**Re: Galles Chevrolet Parking Lot on B D P Inc.'s property at 2007 Candelaria Rd. NE
Erosion and Sediment Control Plan – H15E029
Engineer's Stamp Date 2/26/26 (SWQ-2026-00016)**

Based on the information provided in your submittal, received on 2/26/26, the ESC Plan cannot be approved until the following comments are addressed and the ESC Plan and SWQ Information sheet are resubmitted in ABQ-PLAN.

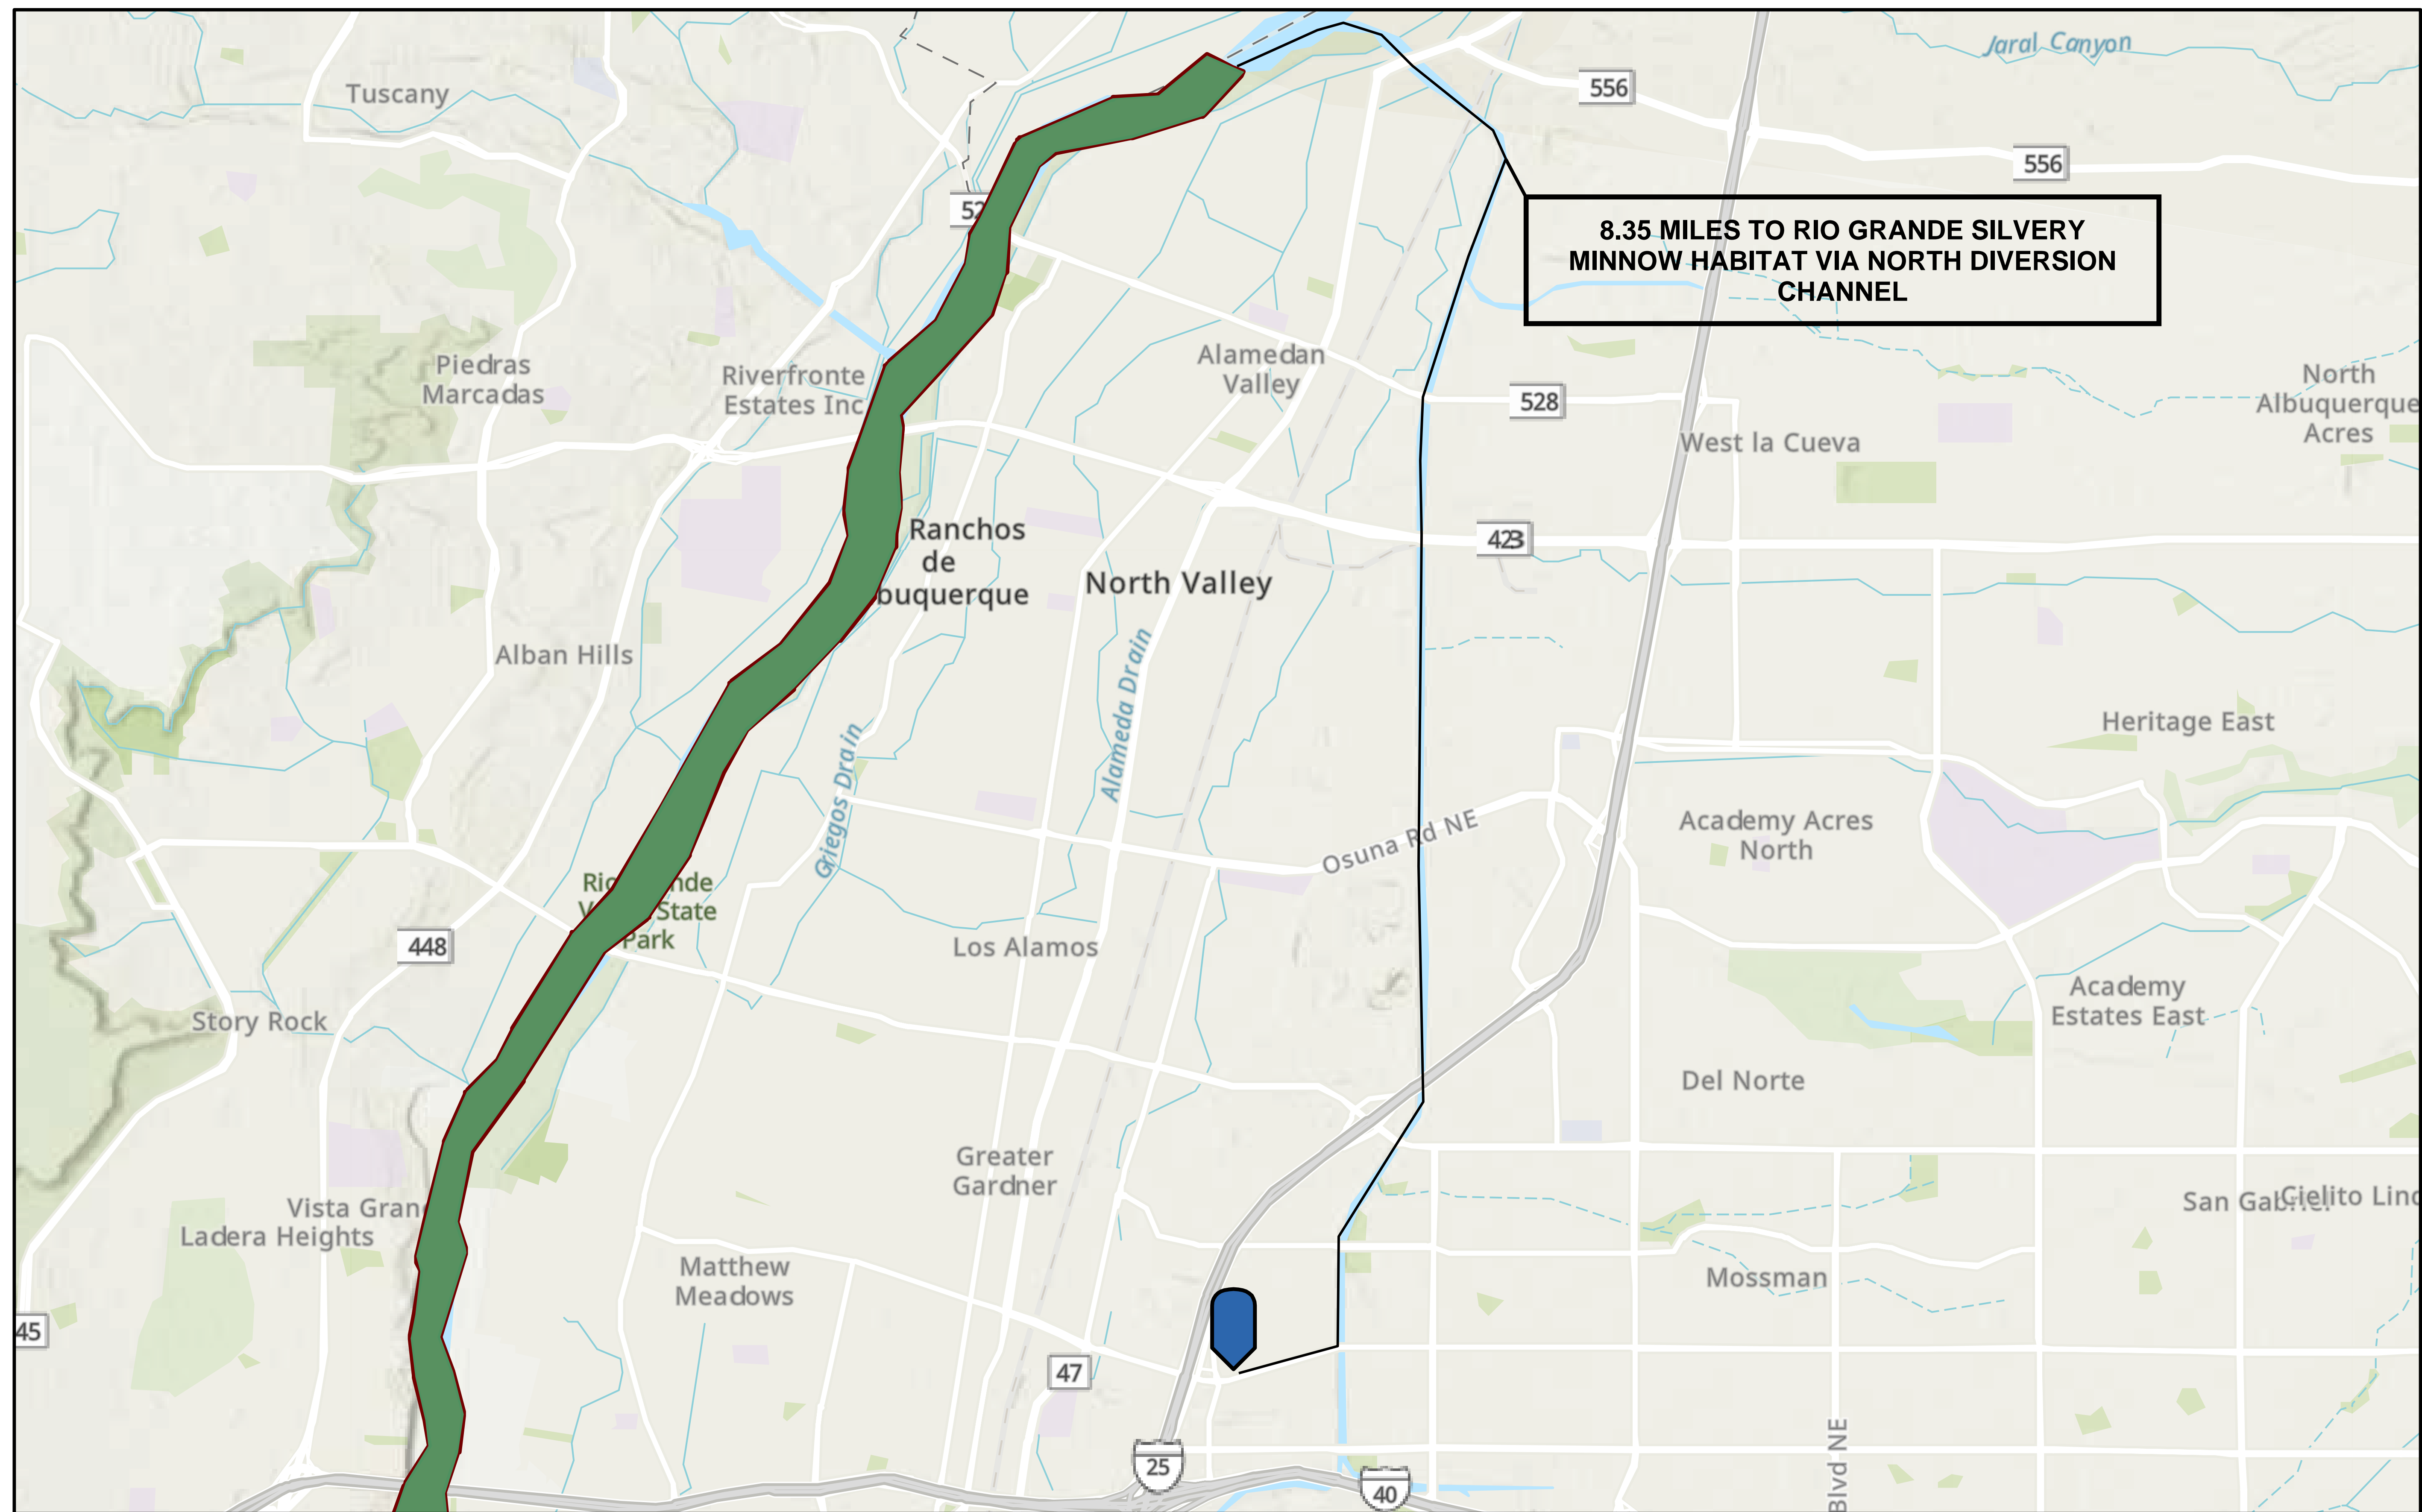
2. Replace the city standard notes on sheet 2 of the ESC Plan with the current version (attached)
3. This site drains through a series of storm drains on 2nd St. south to Iron Ave, then to the Iron Pump station about 3.5 miles southwest from the site, where it is discharged into the Rio Grande. Correct the map on sheet 2 of the ESC Plan.

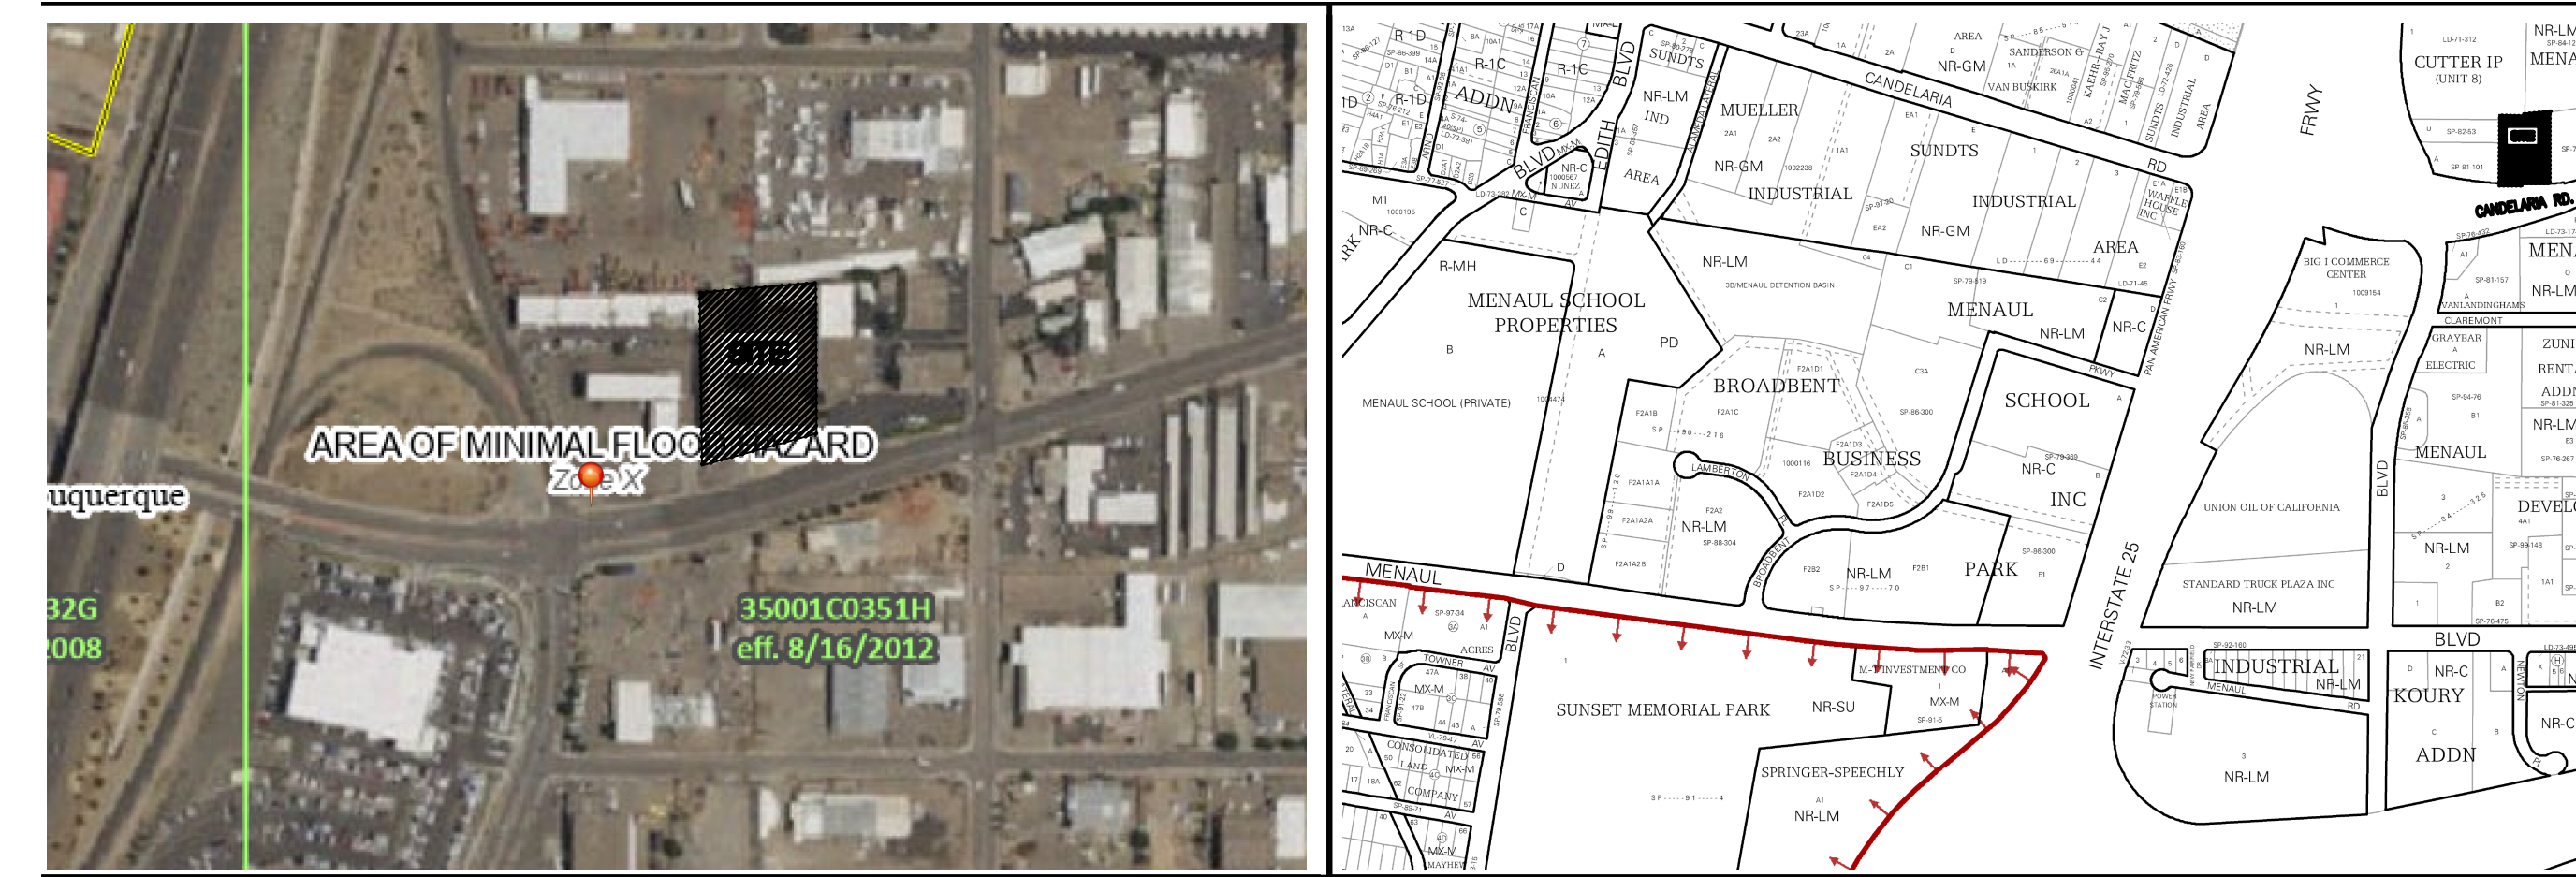
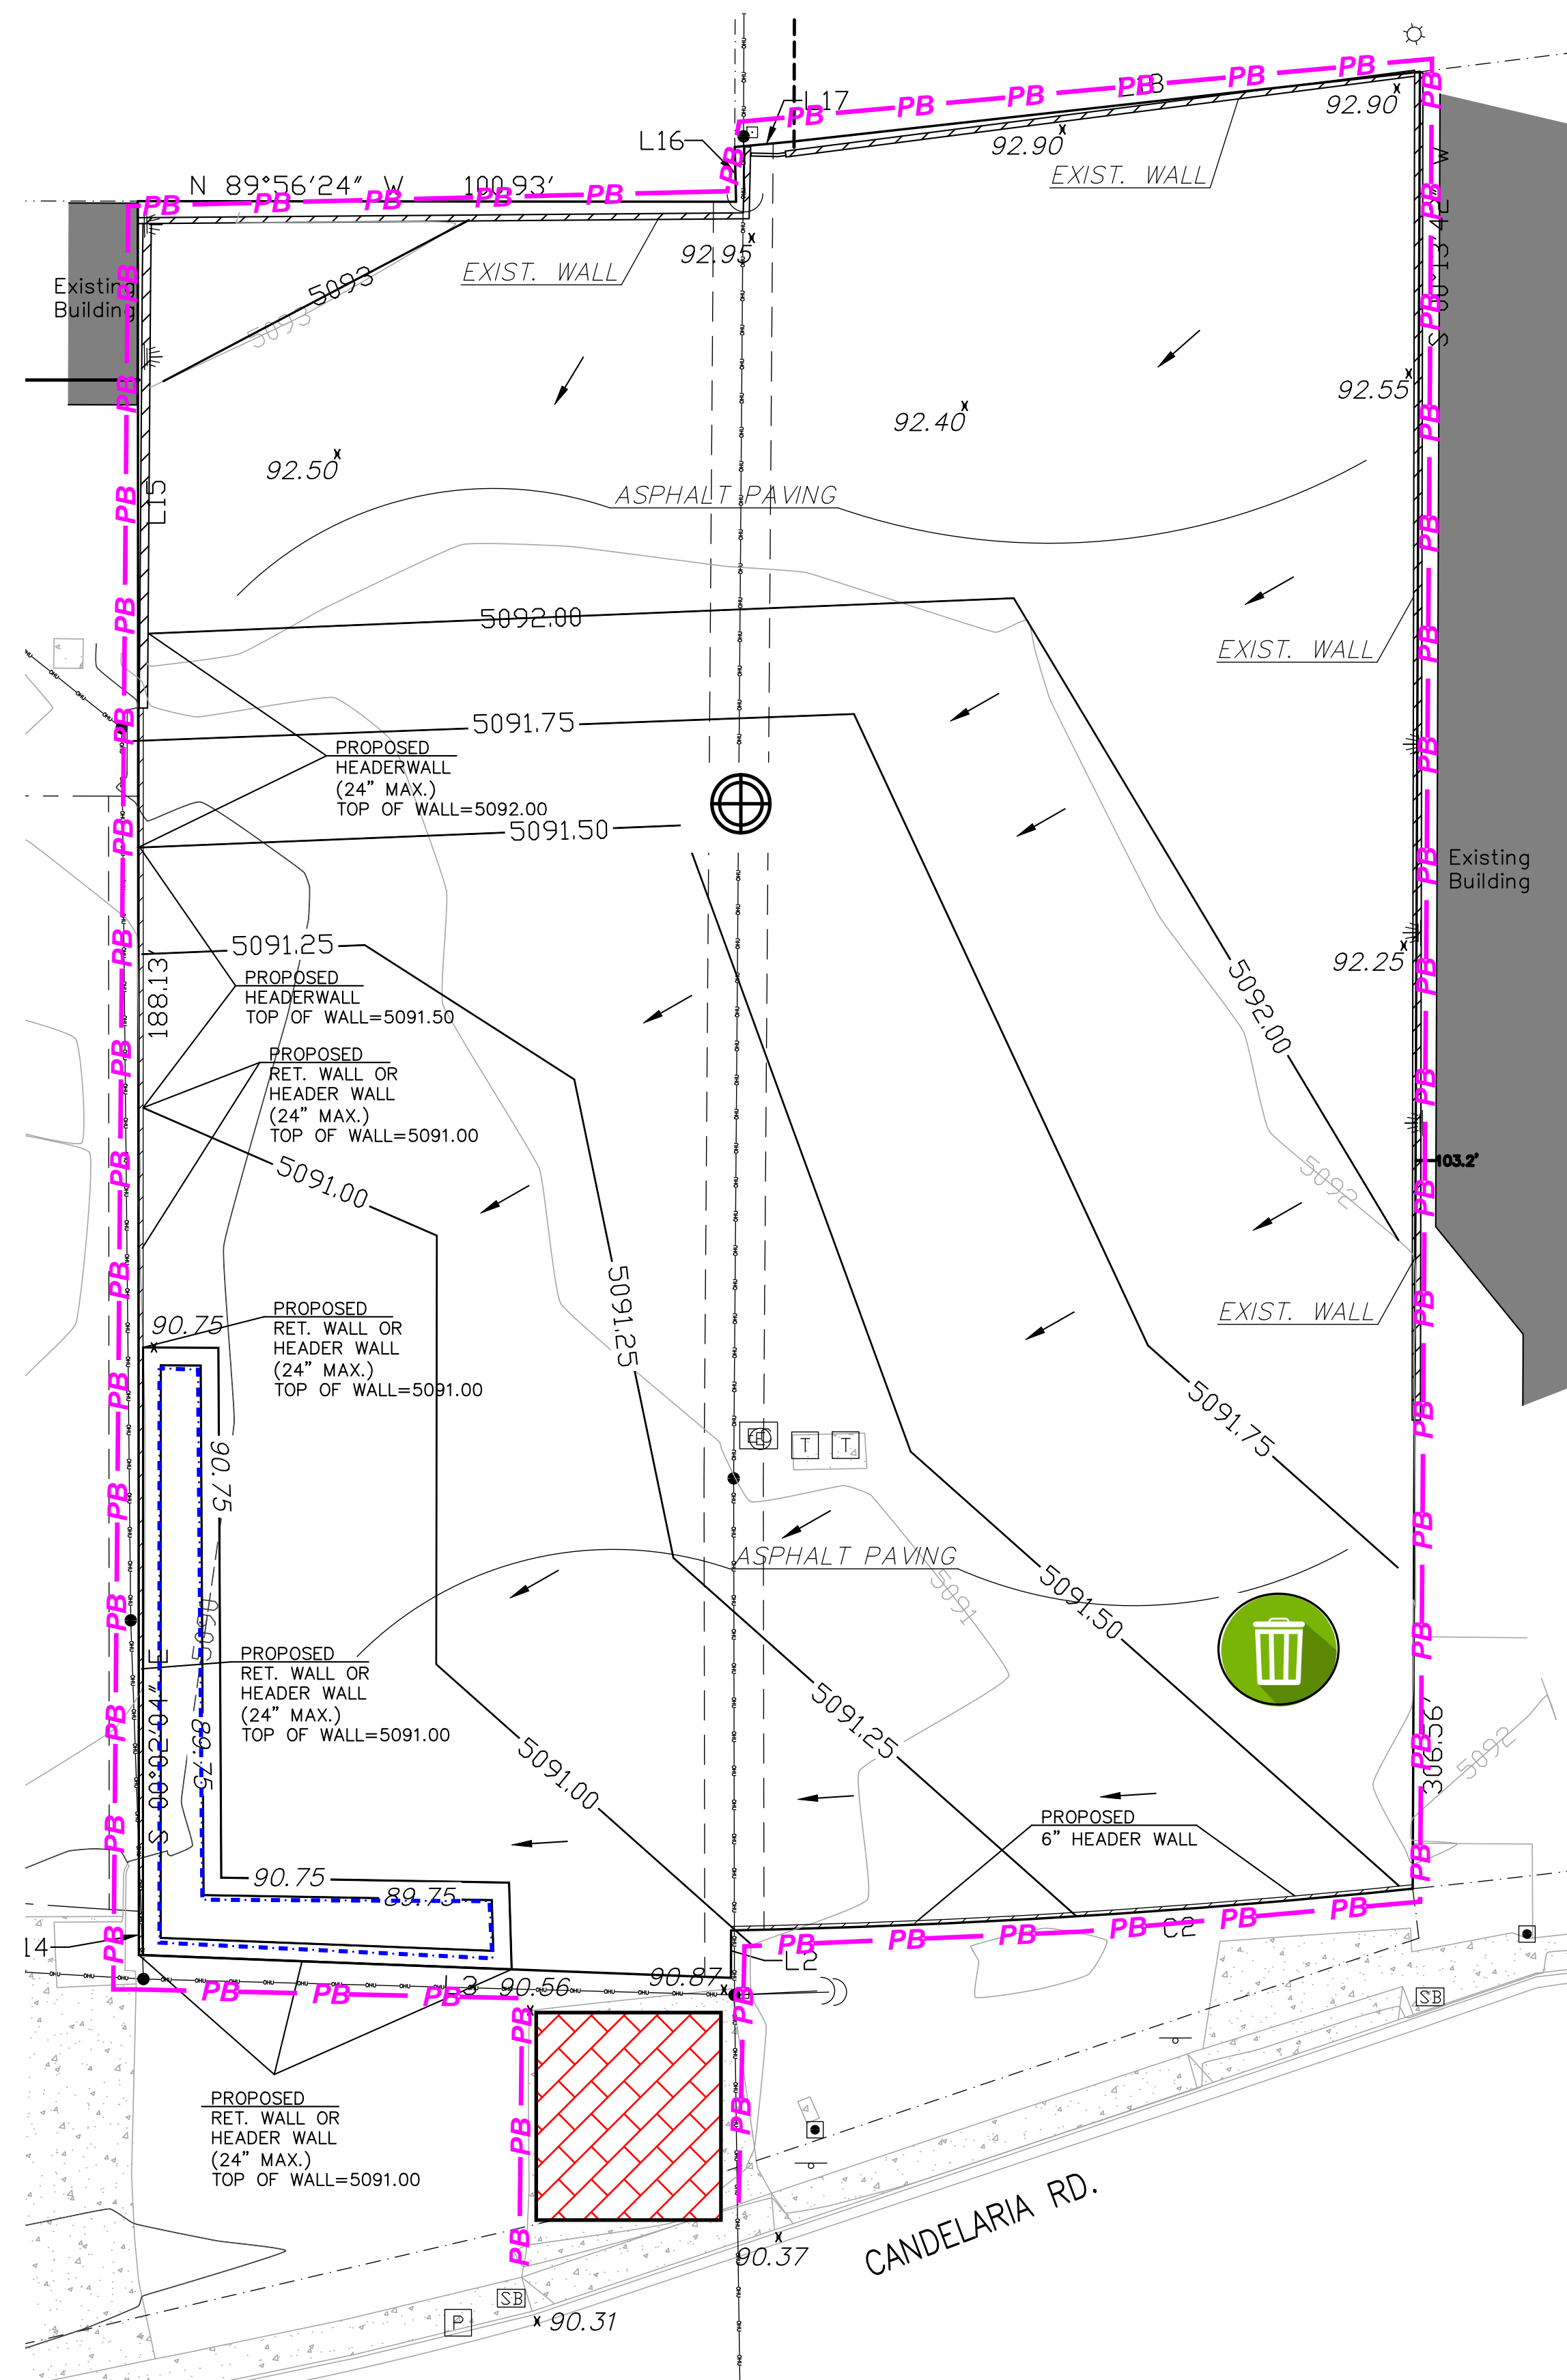
4. Please correct the property owner information and NPDES Id # on Sheet 3 of the ESC Plan.
5. A shallow ponding area was graded during earlier construction activities in the southwest corner of the site. The new, deeper pond shown on sheet 4 of the ESC Plan should be prioritized as one of the first construction tasks, along with diversion channels along the south and west sides of the site to direct stormwater to the pond during construction. The stabilized asphalt entrance doesn't provide sufficient agitation to remove sediment and mud before vehicles exit this site. Use an appropriate Construction Exit detail and move the exit out of the public right-of-way. Please add appropriate construction specifications to the ESC Plan.
